OXFORDSHIRE COUNTY COUNCIL'S RESPONSE TO CONSULTATION ON THE FOLLOWING DEVELOPMENT PROPOSAL

Application no: 21/04144/F

Proposal: Demolition of existing office block and erection of surface level car park providing 215 replacement car parking spaces, including landscaping and other associated works; new main entrance and reception of the Computer Suite, with external re-cladding

Location: Jacobs Douwe Egberts, Ruscote Avenue, Banbury

JOB NO. 16061	DRAWING (03)-S-001	REV PL1
------------------	-----------------------	------------

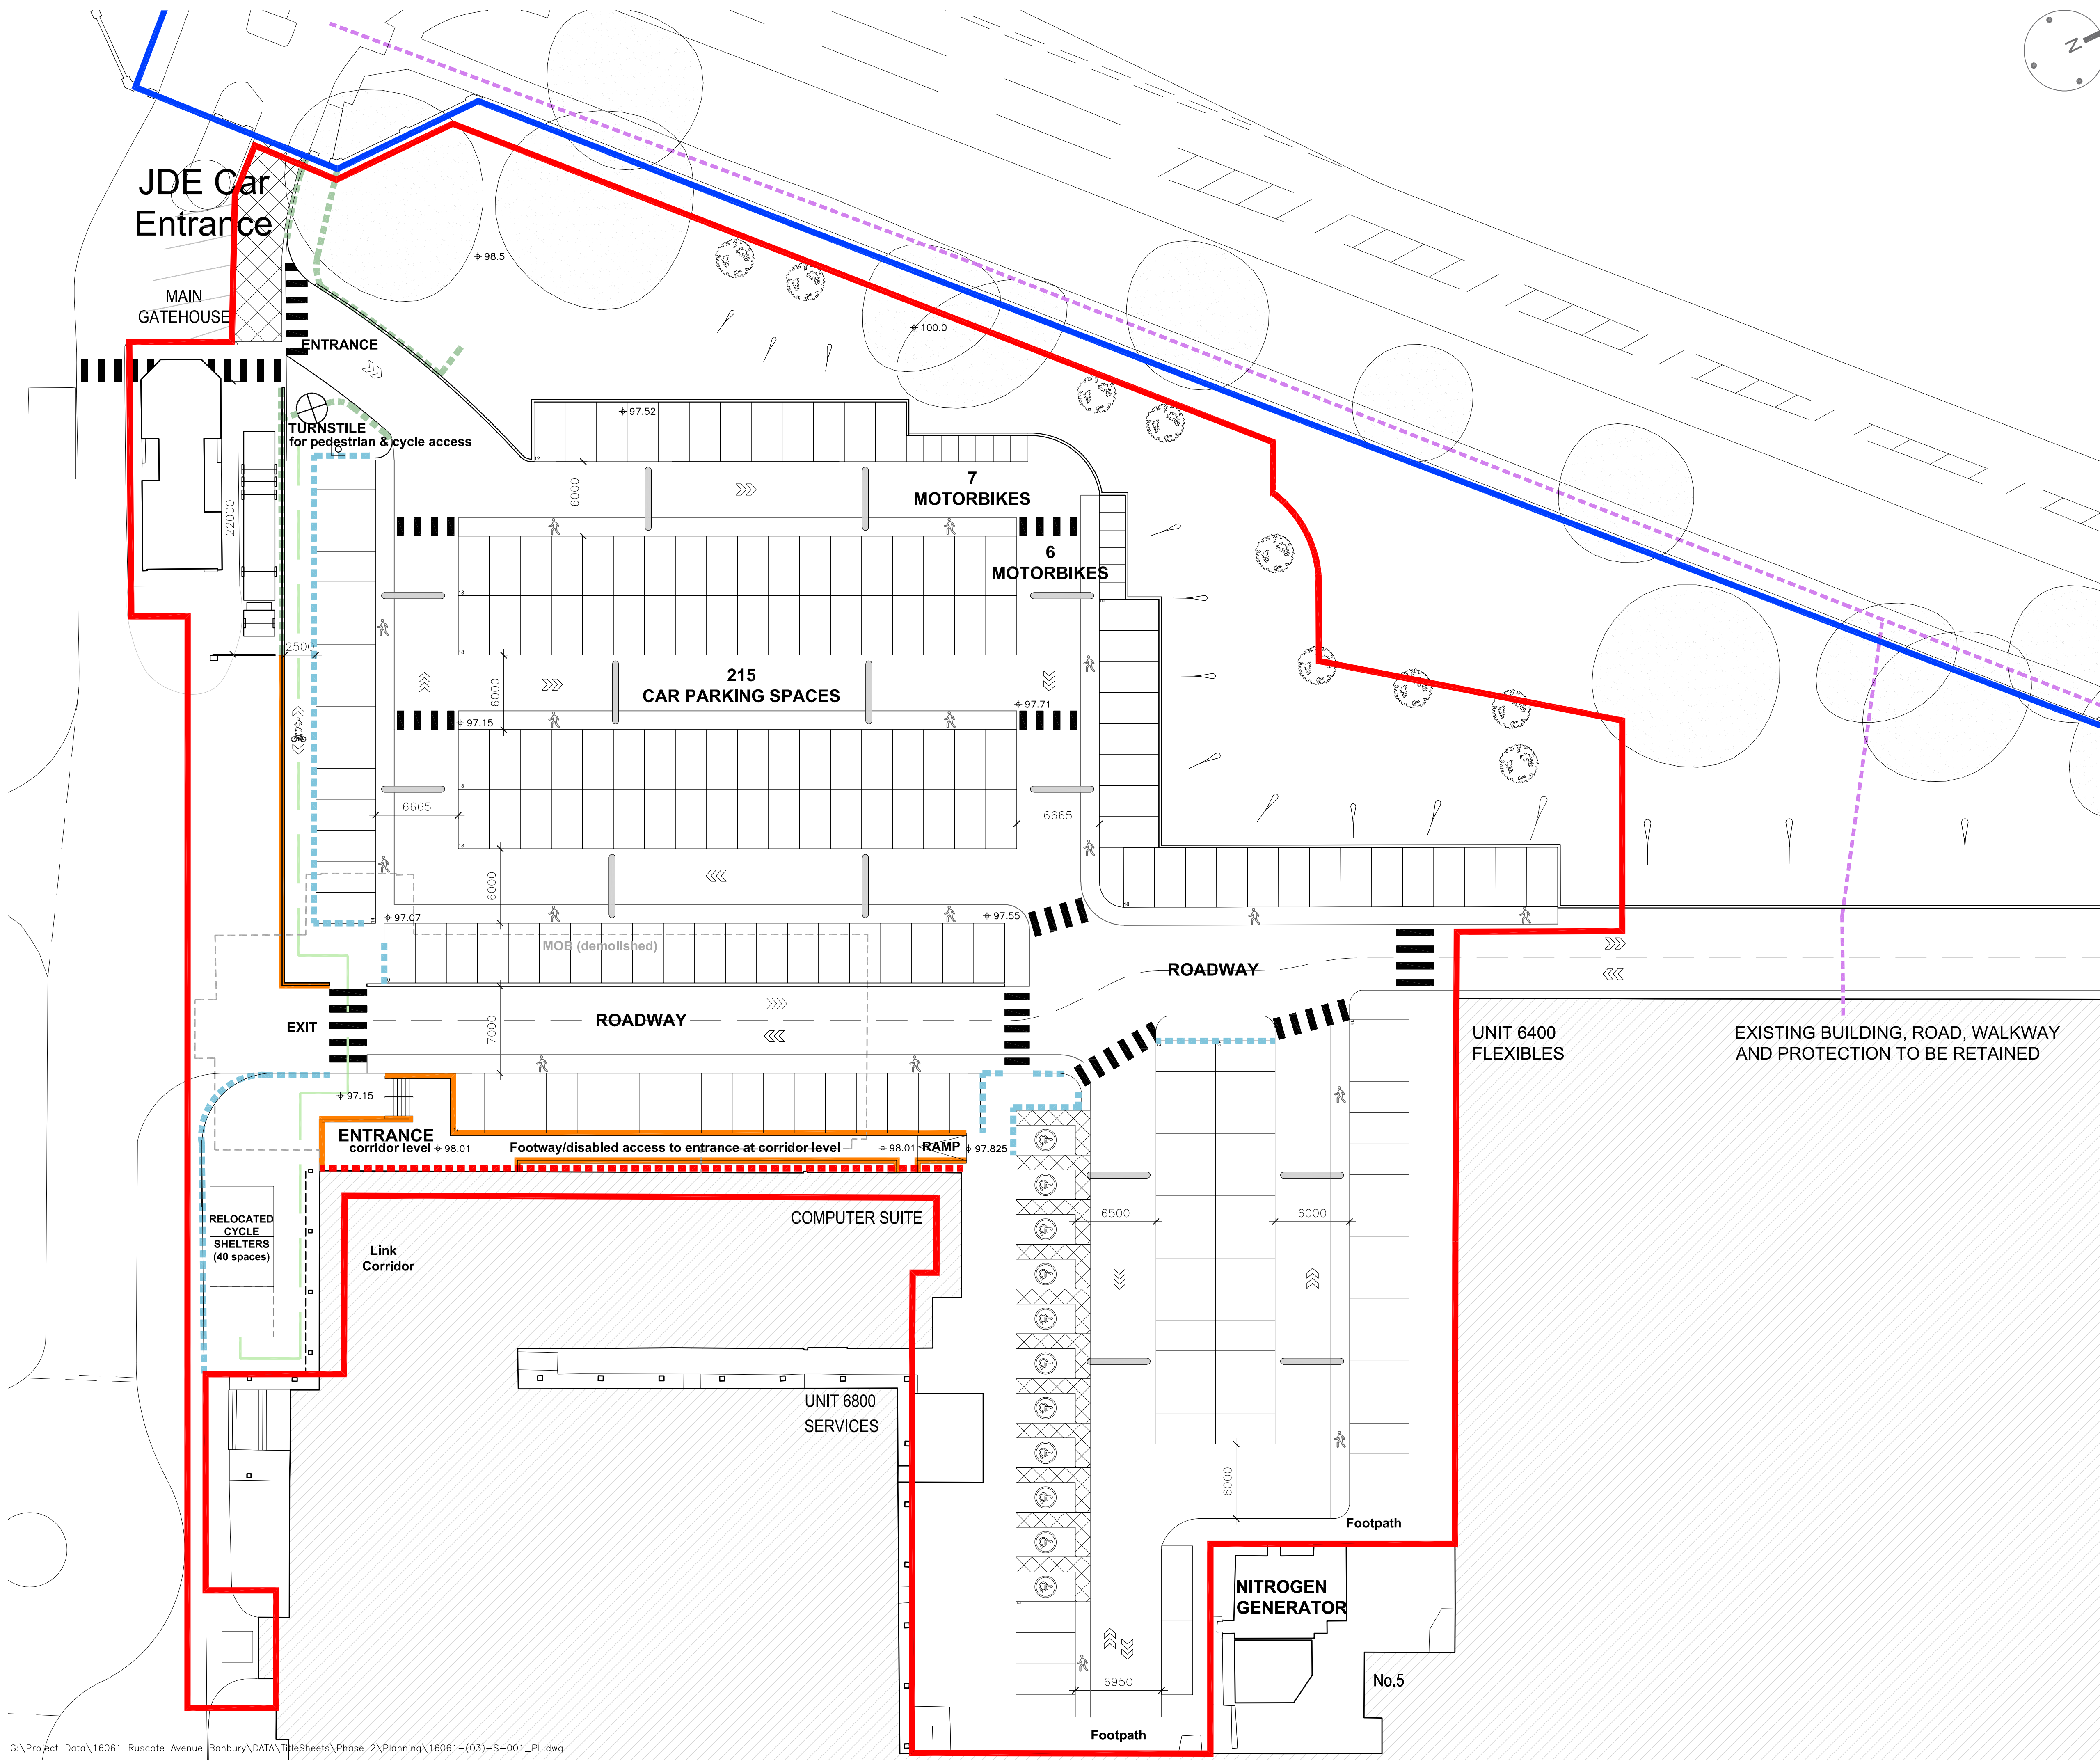
Access to the car park will be taken from the existing wide bellmouth junction with Ruscote Avenue. There are islands and a gatehouse within the access road, which will be shared with HGVs entering the site, but the entrance into the car park is before the gatehouse. The Proposed Block Plan of Site, drawing no. (03)-S-001 Rev. PL1, shows an HGV stopped at the barrier. However, I presume it would be usual for the HGV to stop initially so that the cab is alongside the gatehouse window, but this would cause the tail end of the HGV to obstruct the car park entrance. This situation must be avoided otherwise any following vehicles may queue back to and obstruct the highway if they cannot get directly into the car park.

Parking bays scale to 4.8m long but they should be 5.0m in accordance with the Oxfordshire Street Design Guide. The 6.0m gaps between bays are adequate for manoeuvring.

At present, visitors to the site would pass by the gatehouse to sign in. Is this still the intention with the new layout? If so, they could only then access the car park via the opening marked “EXIT”, although the roadway is two-way so this route would be possible.

Section 3.2 of the Design and Access Statement says “*Provisions for electric car charging facilities will be located in front of the building*” but these are not indicated on the Plan. 25% of all unallocated parking spaces must be provided with EV charging to be in accordance with Policy EVI 8 of the Oxfordshire Electric Vehicle Infrastructure Strategy, which was adopted in 2021.

Prior to the commencement of the development hereby approved, a plan showing a car parking provision for 215 spaces to be accommodated within the site to include layout, surface details, and drainage, shall be submitted to and approved in writing by the Local Planning Authority. Thereafter, and prior to the first occupation of the development, the parking spaces shall be laid out, surfaced, drained and completed in accordance with the approved details and shall be retained for the parking of vehicles at all times thereafter.

Prior to first occupation the applicant must submit plans to the Local Planning Authority for the Electric Vehicle Charging points across the site in line with Policy EVI8 of the Oxfordshire Electric Vehicle Infrastructure Strategy and thereafter construct according to the approved plans.
